City of Albuquerque Stormwater Construction Site Inspection Report

ESC File No.	M21E018_R	Project Name:	Raylee Homes at Juan Tabo Hills Estates		
NPDES Id. No.	NMR1002FM	Location:	Popejoy, Rodey, and Sunset		
8/19/2022	Owner	Deligated Authority			
Operator	SLG Holdings, and TJT Group, LTD.		Raylee Homes field super		
Contact name & title	Jeff Grady		Sal Chavez		
e-mail	jgrady@rayleehomes.com				
Contact Phone #	505-975-7544		975-1505		
COA Inspector	James Hughes		Start/End Time:	1:30pm	
Construction Phase:	Vertical				
Type of Inspection:	Regular	Storm Event	Past Storm Event >0.25"	311/Complaint	Follow Up
Weather at time of inspection?		Cloudy		Temperature: ~	80
Estimated date of last storm 0.25" or greater			8/21/2022

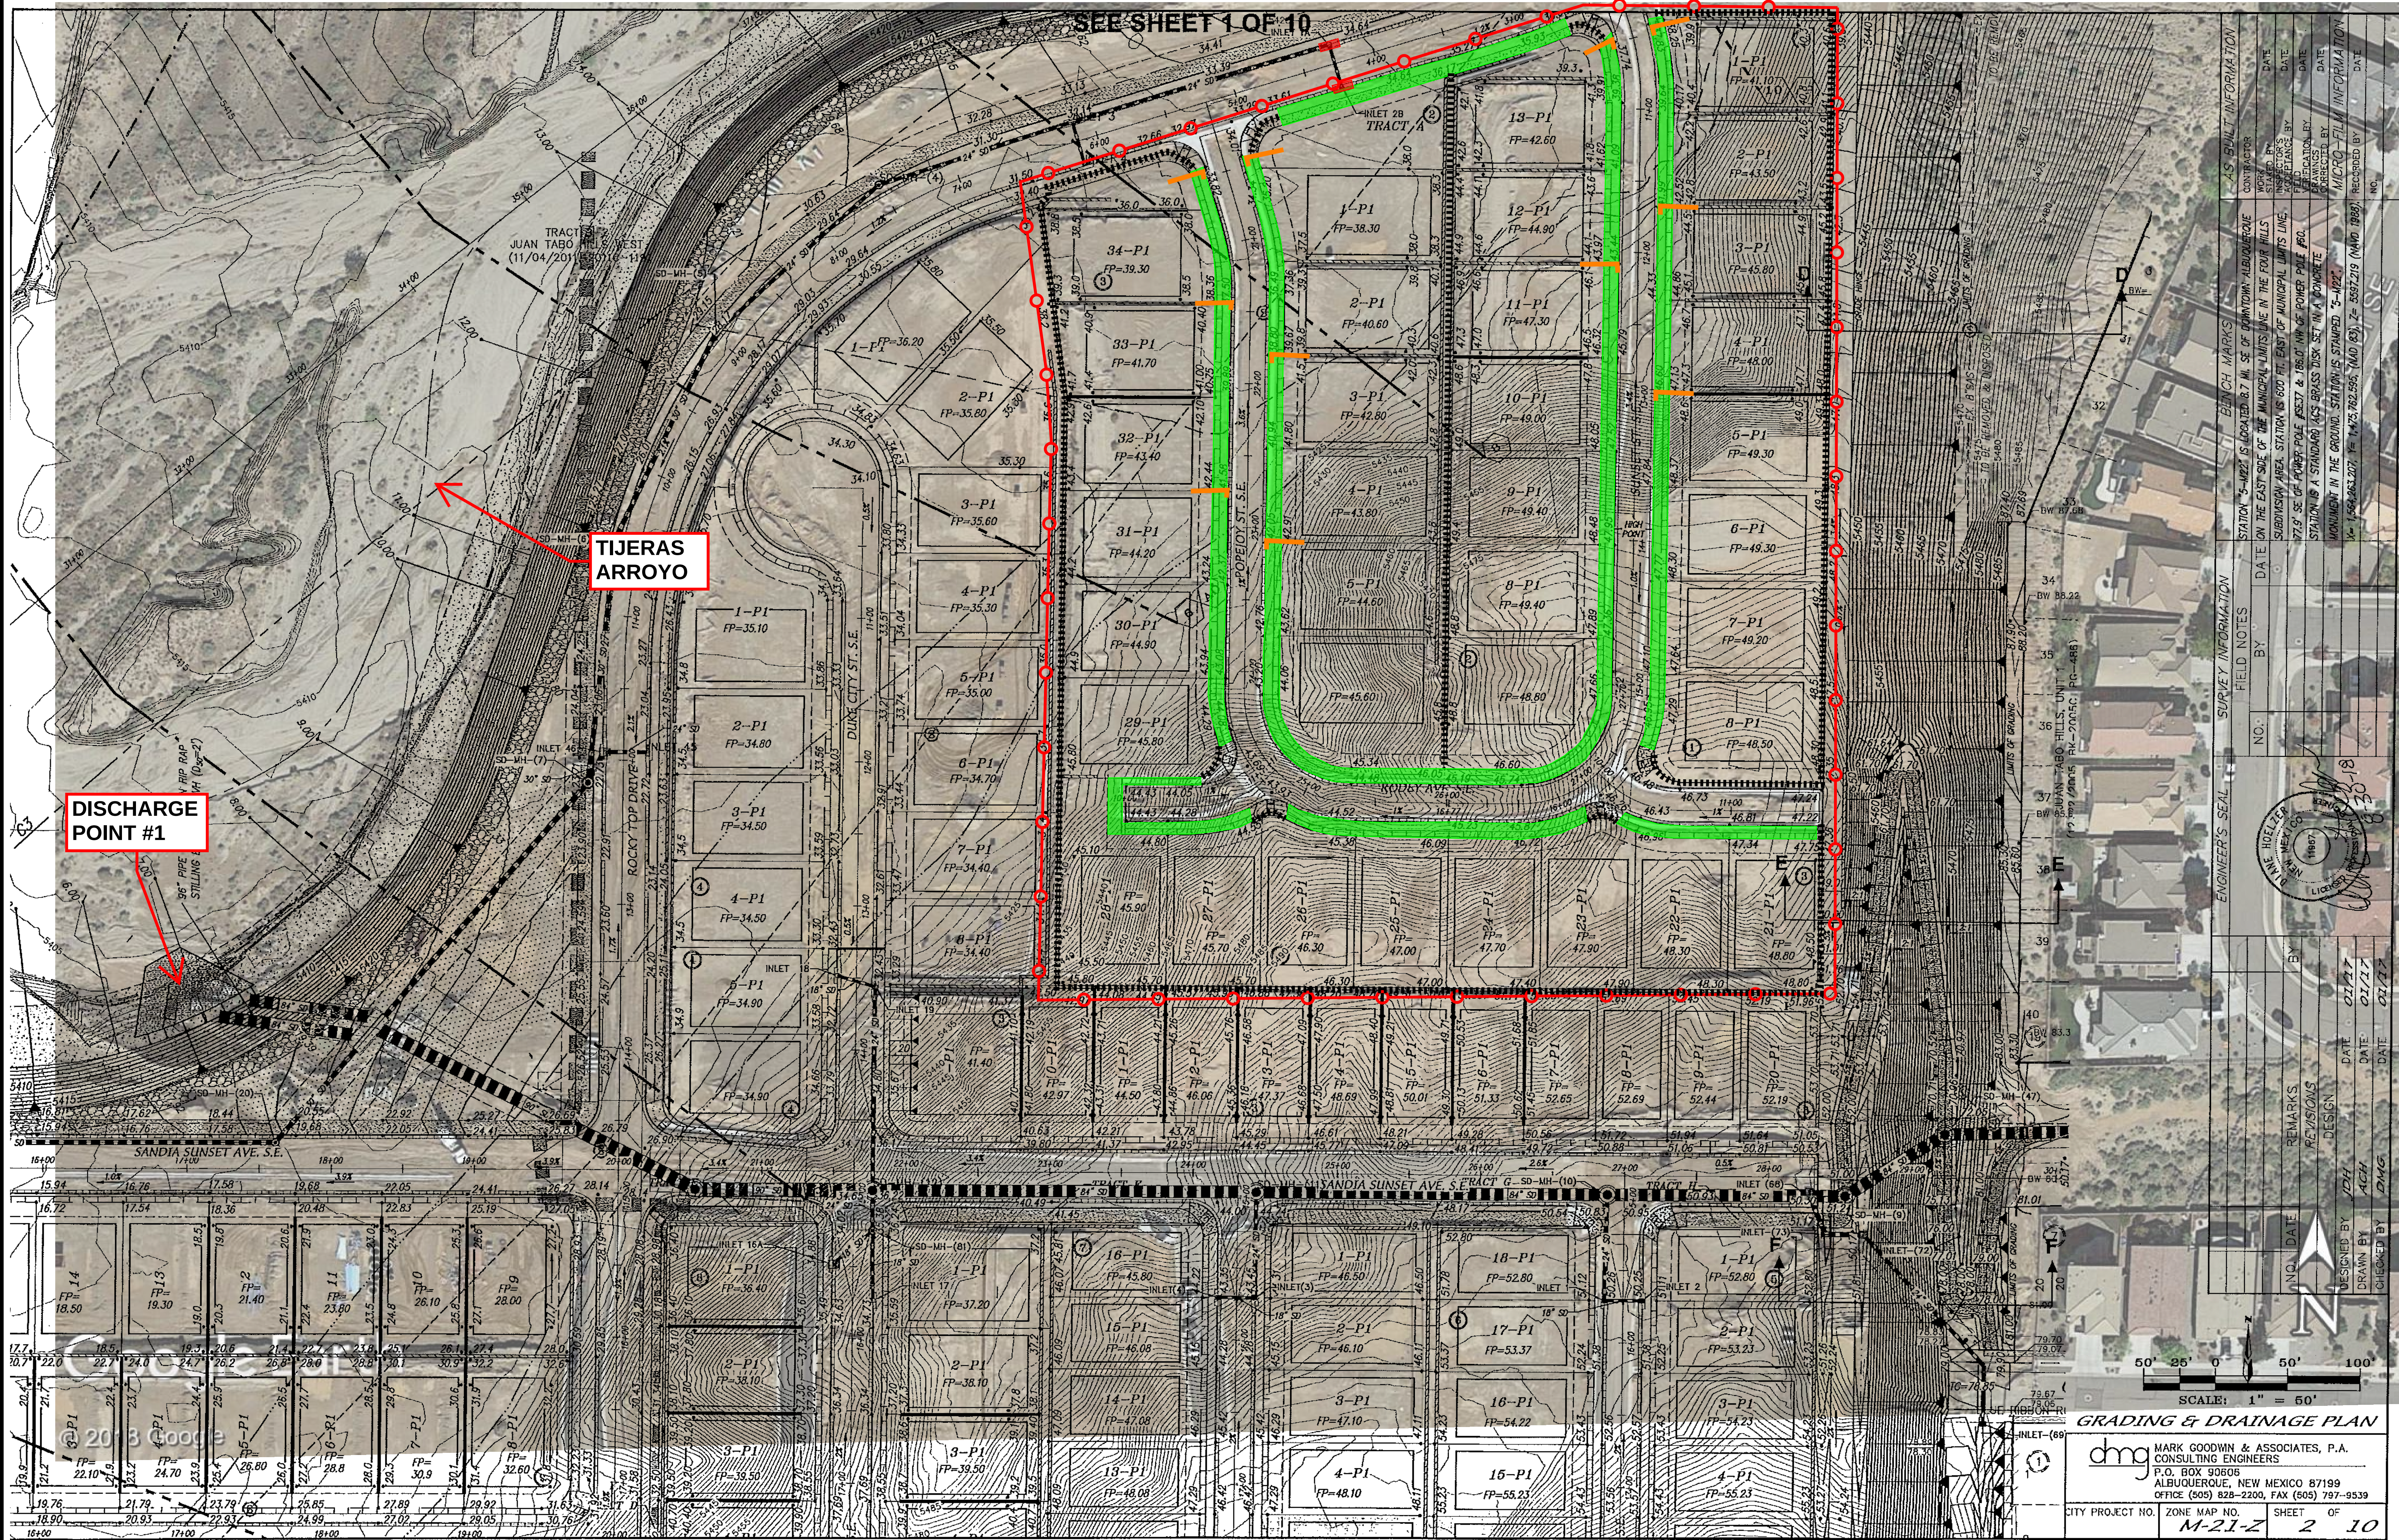
Item Number	Deficiency/ Corrective Action				
1	Remove inlet protection from all inlets downstream of the site in Rocky Top and clean sediment from streets and sidewalks. Keep sediment out of street!				
2	The cutback swale isn't enough. Keep the sediment out of the street by adding silt fence at low corner of each lot 15' x 15'.				
3	Minor washout on nw lot at SWPPP sign. Clean up and add washout containers.				
4					
5
